MECKLENBURG COUNTY  
Land Use and Environmental Services Agency

**Re: Rezoning Petition 2008-077  
Approximately 6.00 acres located between N Wendover Road and  
Billingsley Road at Cascade Circle**

RZ-1

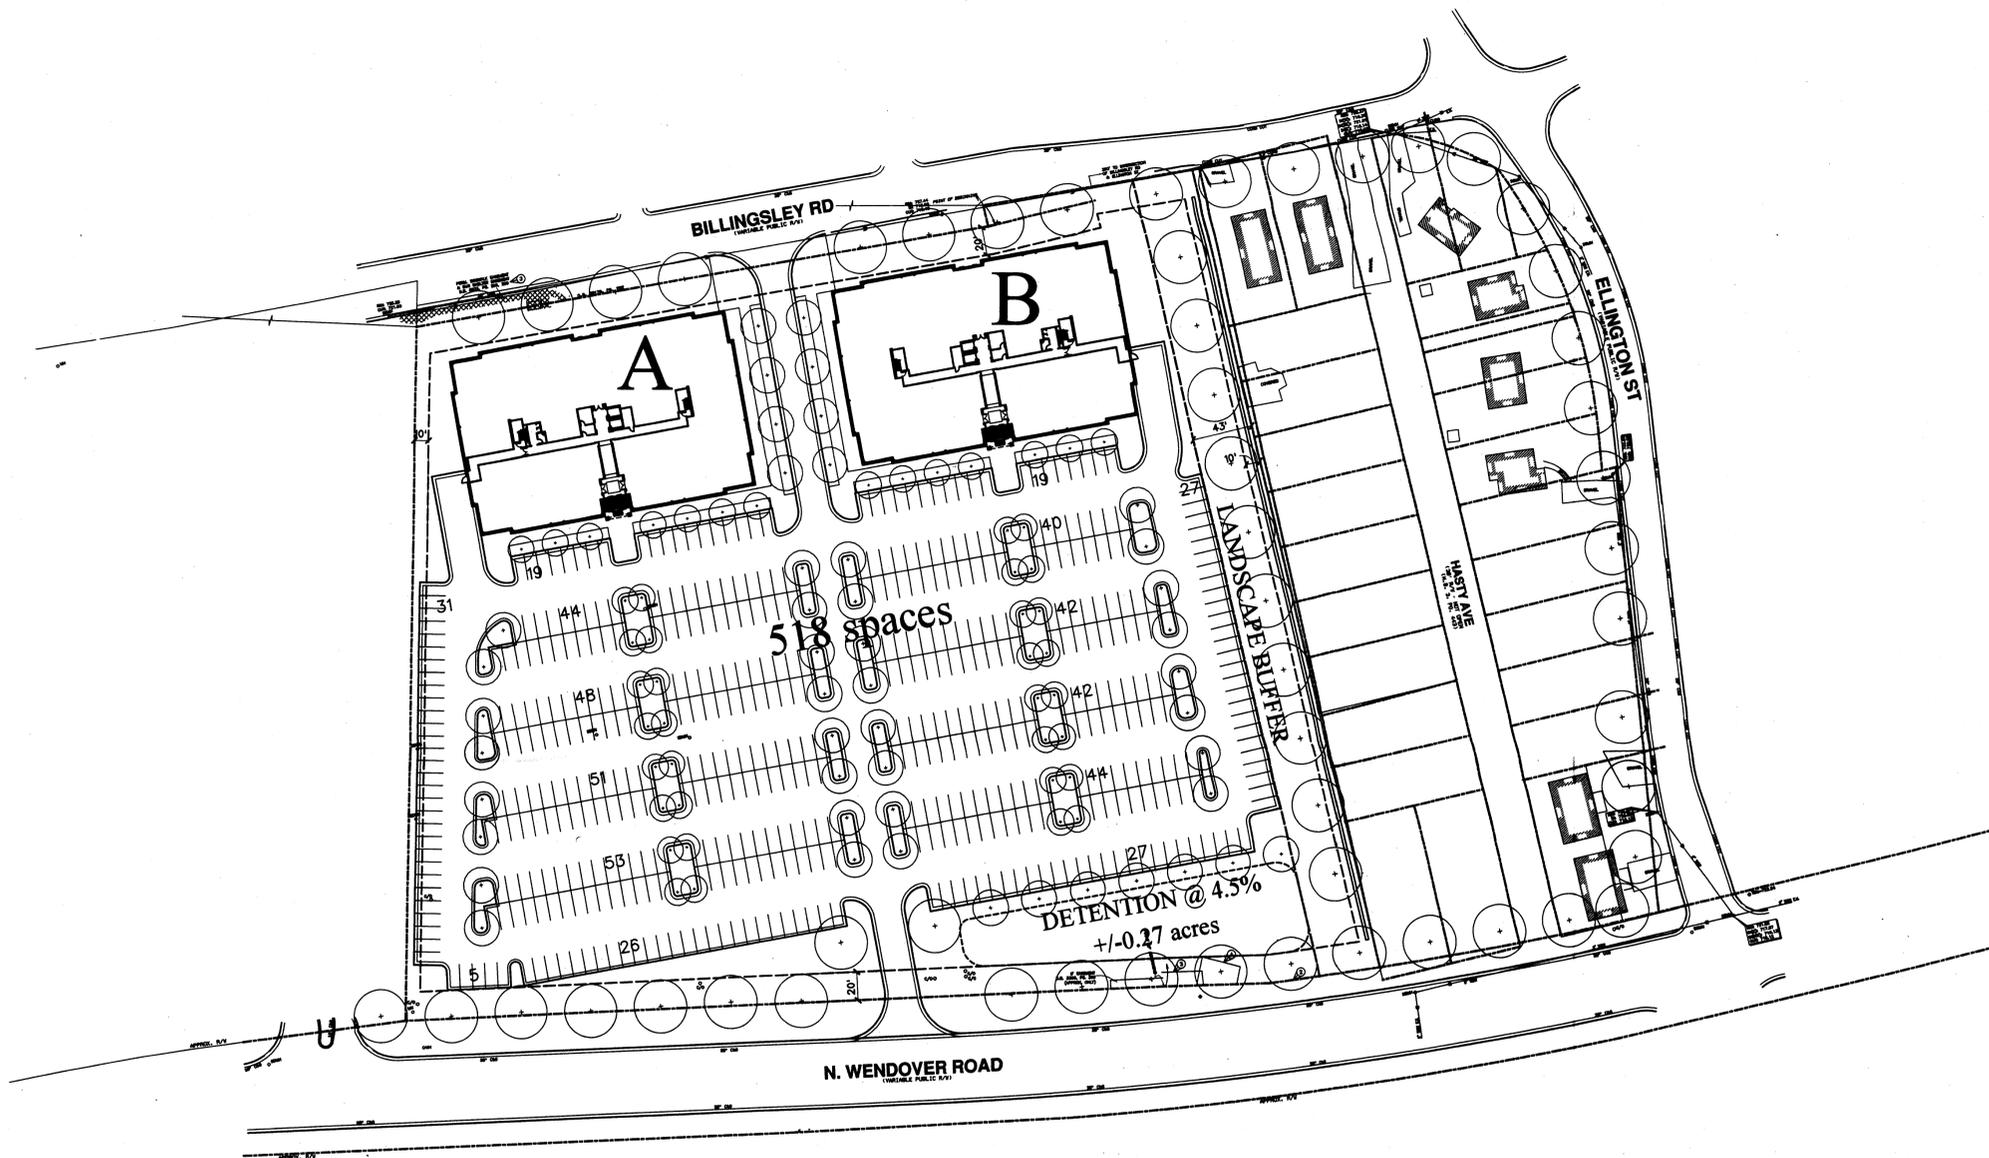
The age of construction of homes on parcels 157-072-08, 157-072-09, 157-072-10, 157-072-11, 157-072-12, and 157 072-15 (built between 1935 and 1964) indicates they may have used oil heat before converting to natural gas. Based on this the properties should be inspected for abandoned underground heating oil storage tanks. Tanks and contents should be removed, following applicable North Carolina Department of Environment and Natural Resources guidance, prior to any demolition or grading activity.

The age of construction also indicates that some of the homes (those built in 1935) may have been served at one time by private water supply wells and individual on-site wastewater disposal systems (septic system) during some portion of their occupancy. GWS recommends the petitioner determine if wells were ever used, and if so, abandon them per the Mecklenburg County Groundwater Well Regulations prior to any demolition or grading activity.

No regulation governs the abandonment of septic systems; however, GWS does recommend that septic tanks be pumped by a licensed waste hauler to removal any residual contents, and then crushed and backfilled. This recommendation is made because tanks that collapse pose a safety hazard and improperly abandoned septic tanks may not be able to support the weight of vehicular traffic, structural foundations, or people.

Groundwater & Wastewater Services request the following statements be added to the notes of the site plan:

All fuel oil storage tanks shall be removed and any related soil contamination remediated to NCDENR standards prior to any demolition or grading activity.

Water supply wells shall be abandoned per the Mecklenburg County Groundwater Well Regulations prior to any demolition or grading activity.

Existing septic tanks shall be located, pumped by a licensed waste hauler to removal residual contents, crushed and backfilled prior to any demolition or grading activity.
